RFI

RFI #: 32
Date: 1/12/2012
Job: EB-02 Keller Springs Lofts
Phone: 877-777-5115

Subject: B2 master Bathroom Toilet

Drawing: Arch 2.7 P2.6
Cost Impact: None

SHEET NUMBER
E-2.7

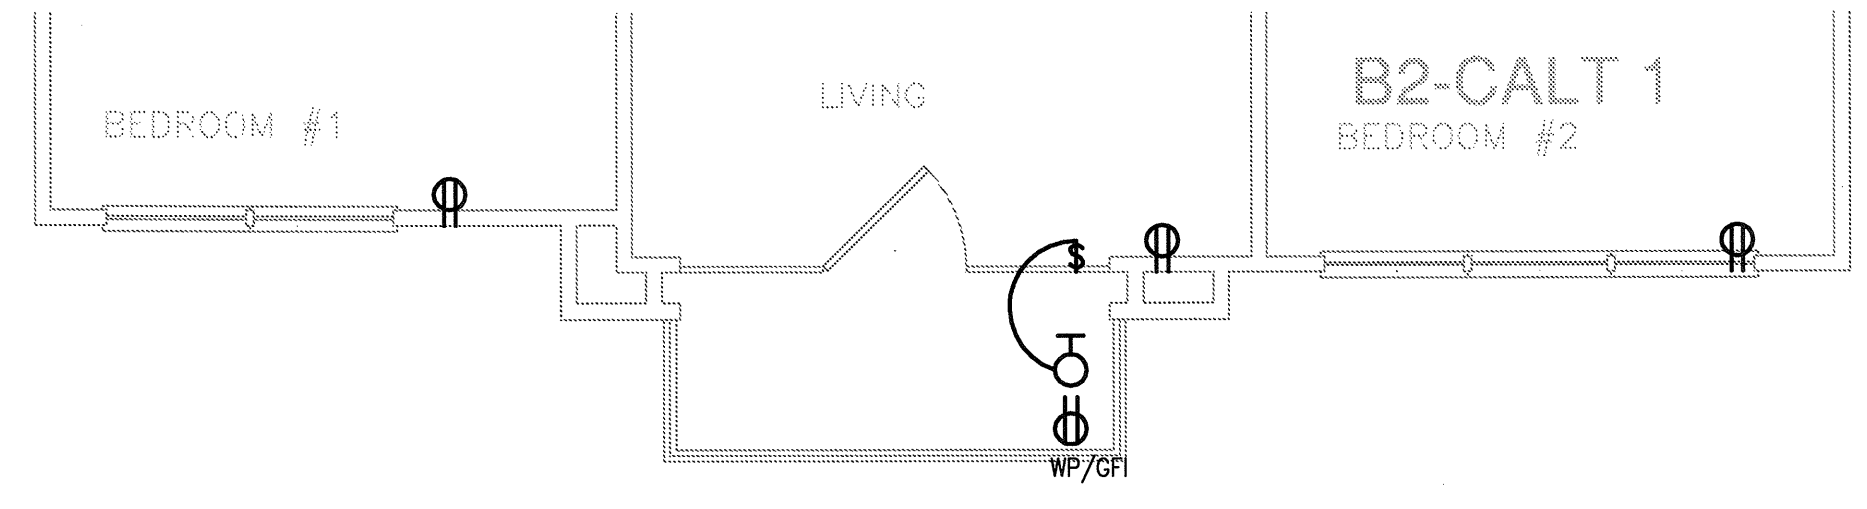
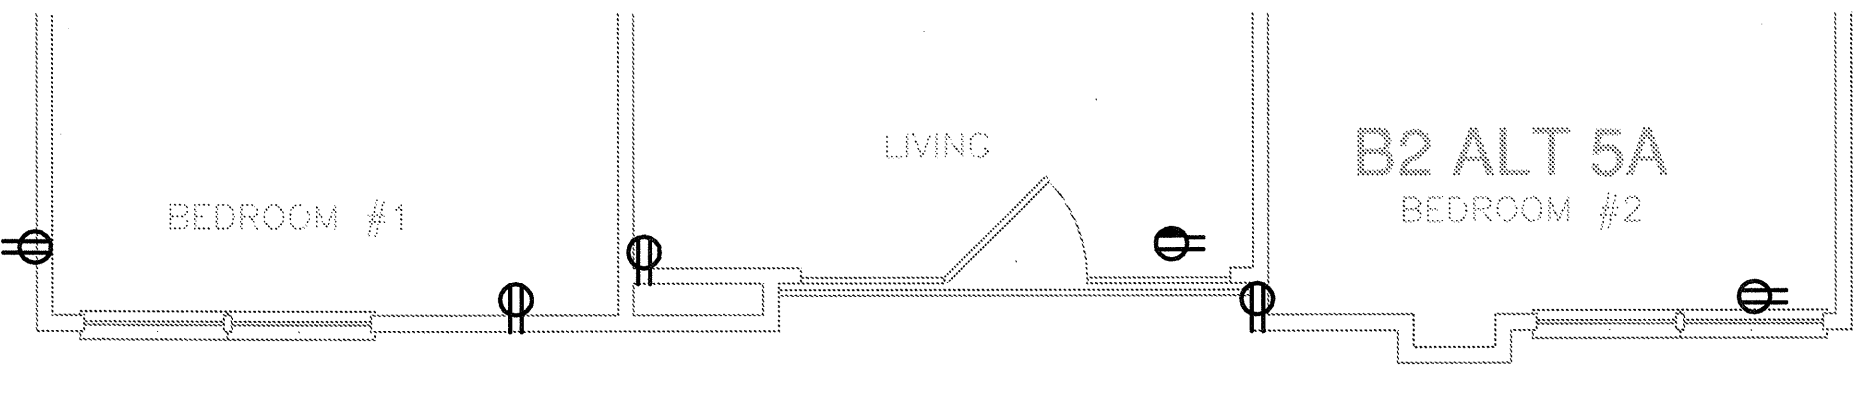
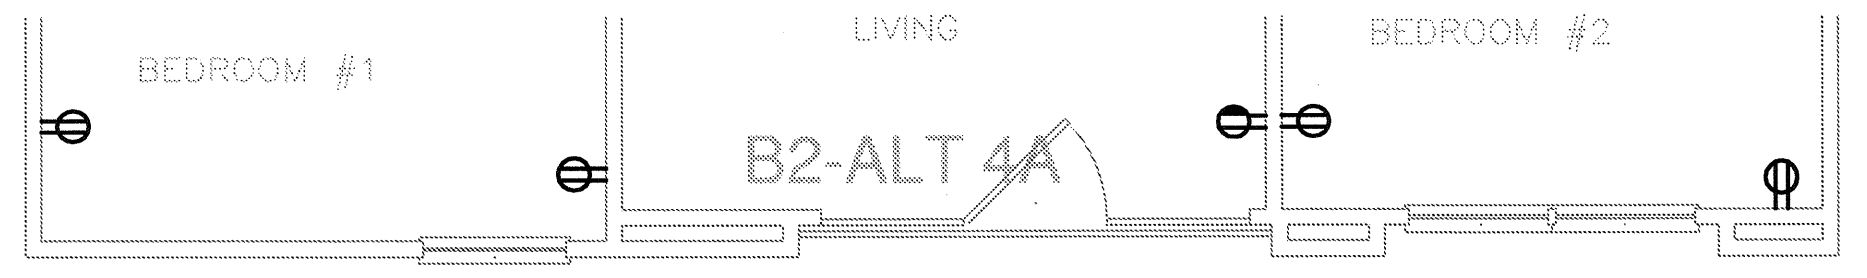
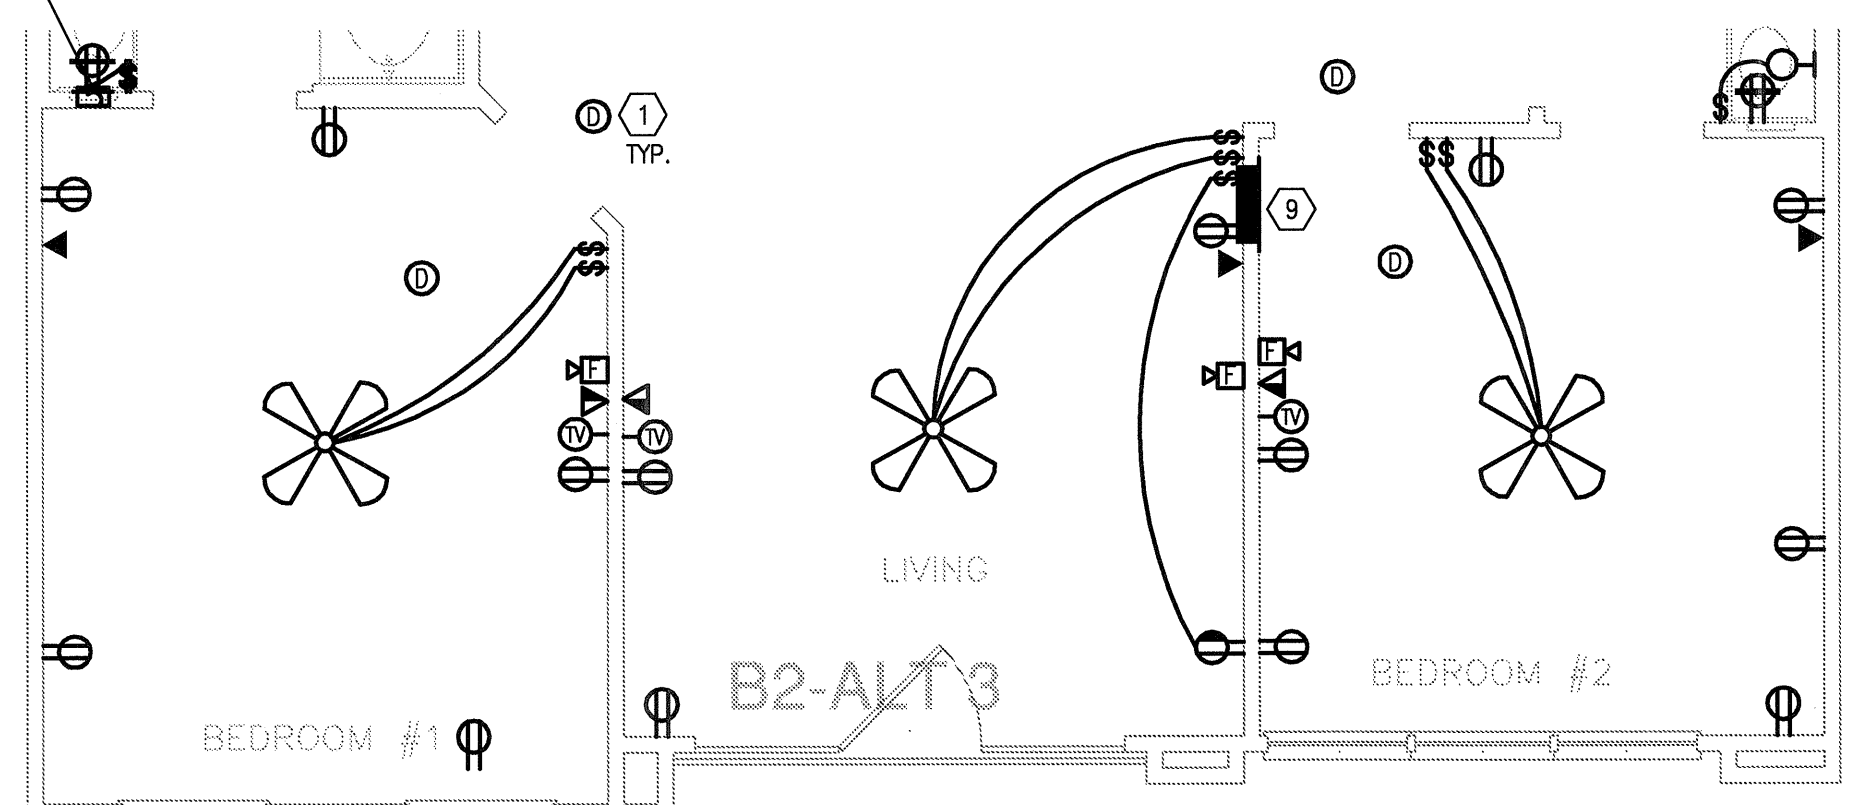
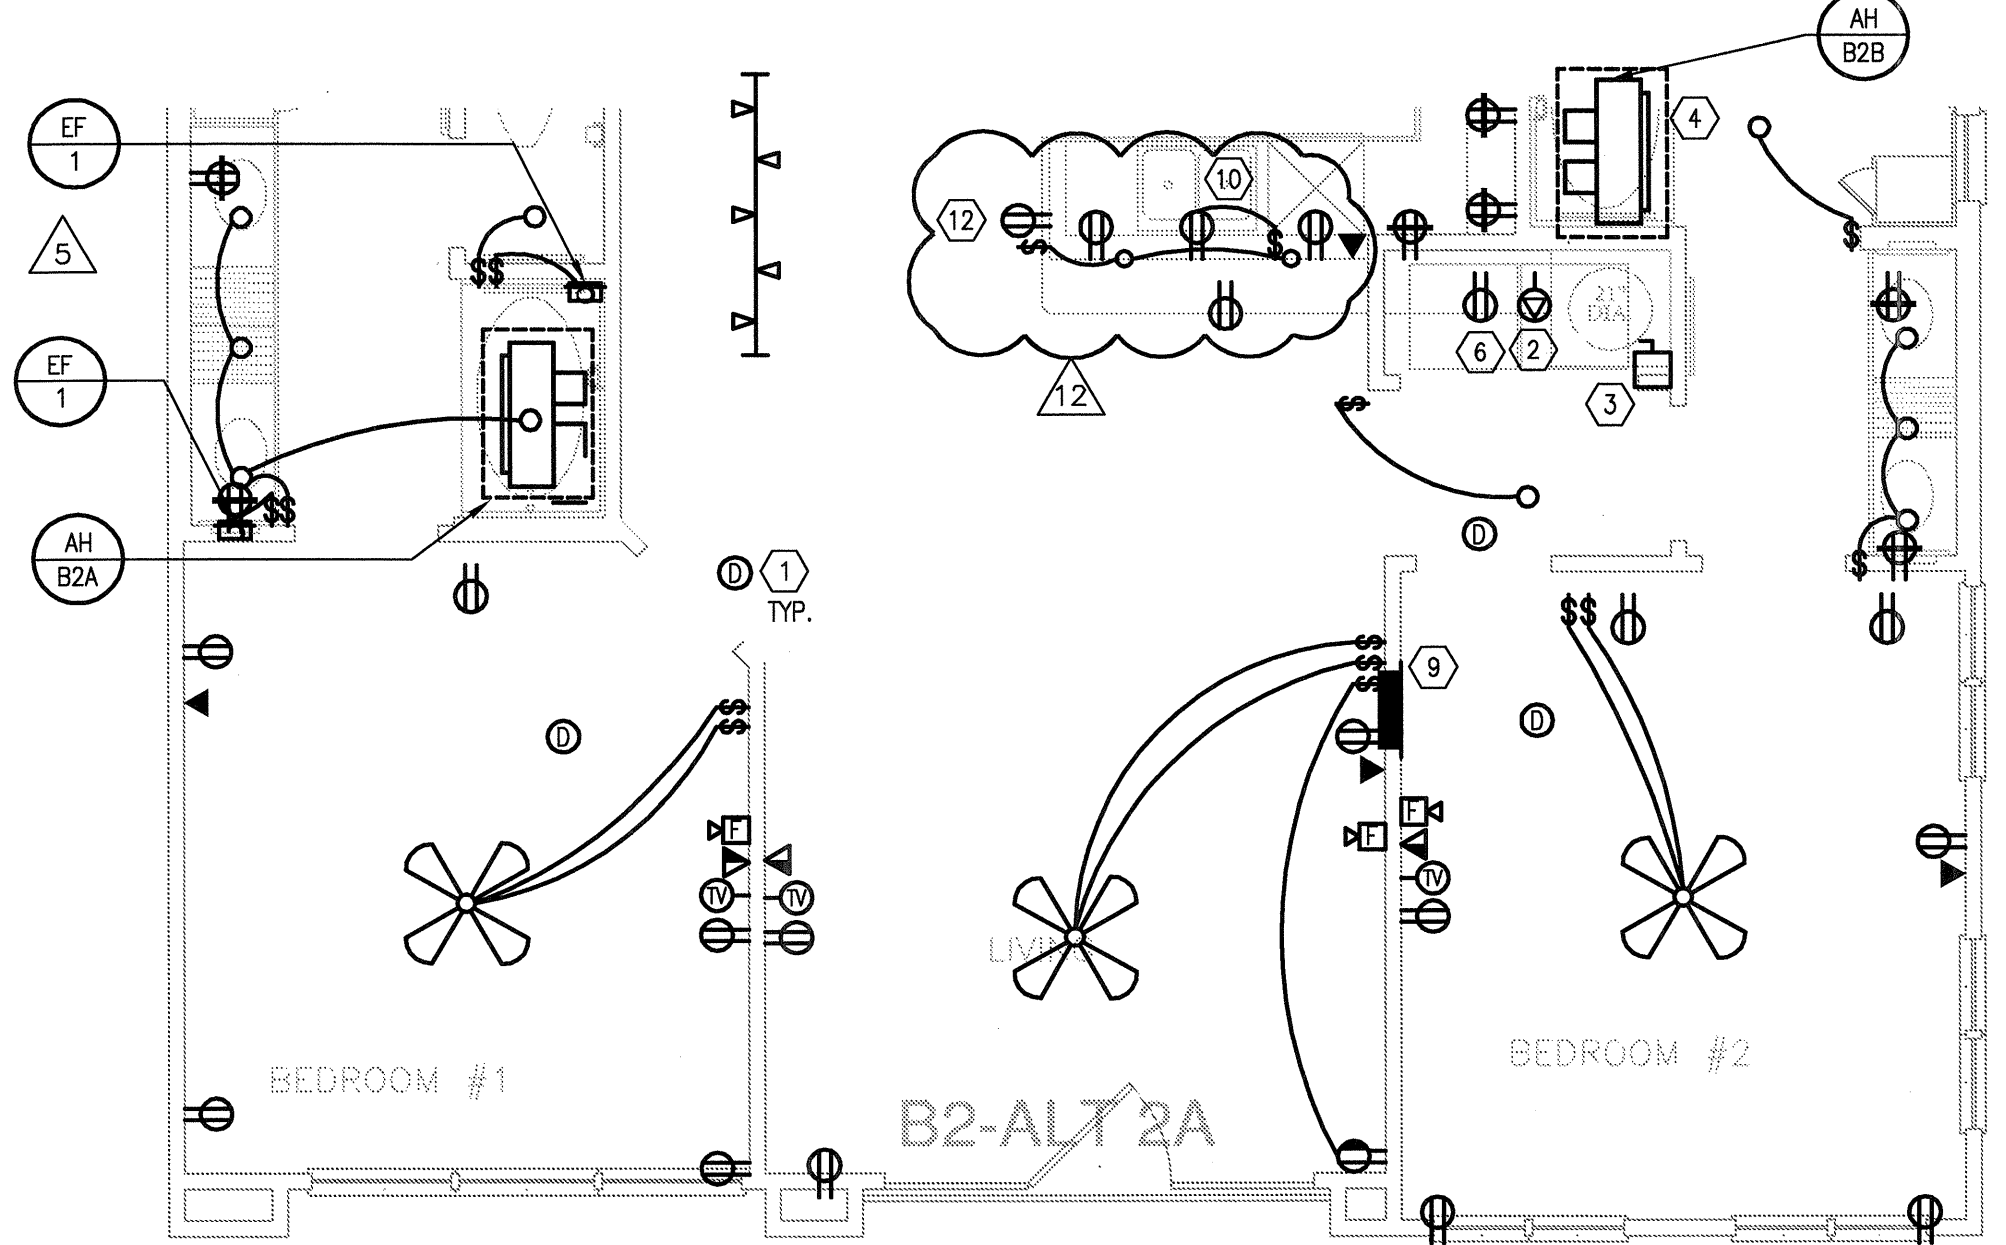
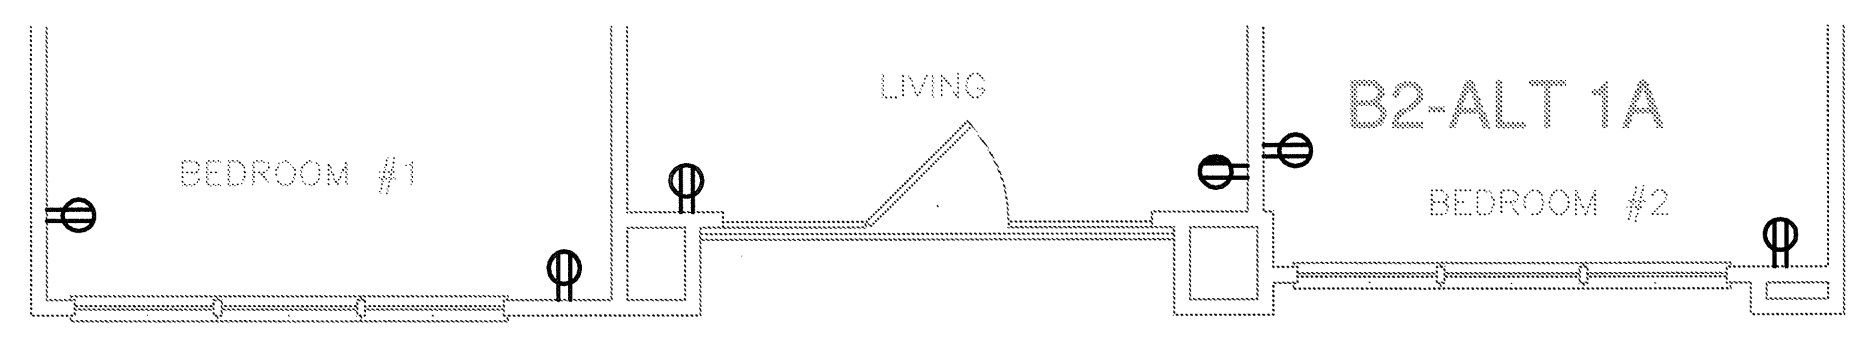
Request: Heath our Plumber requested a RFI. In the master bathroom on the B2 unit the toilet is not centered on the wall is this correct?
Date Required: 1/16/2012

It is acceptable to center the water closet in bathroom #1 for the B2 units as requested.
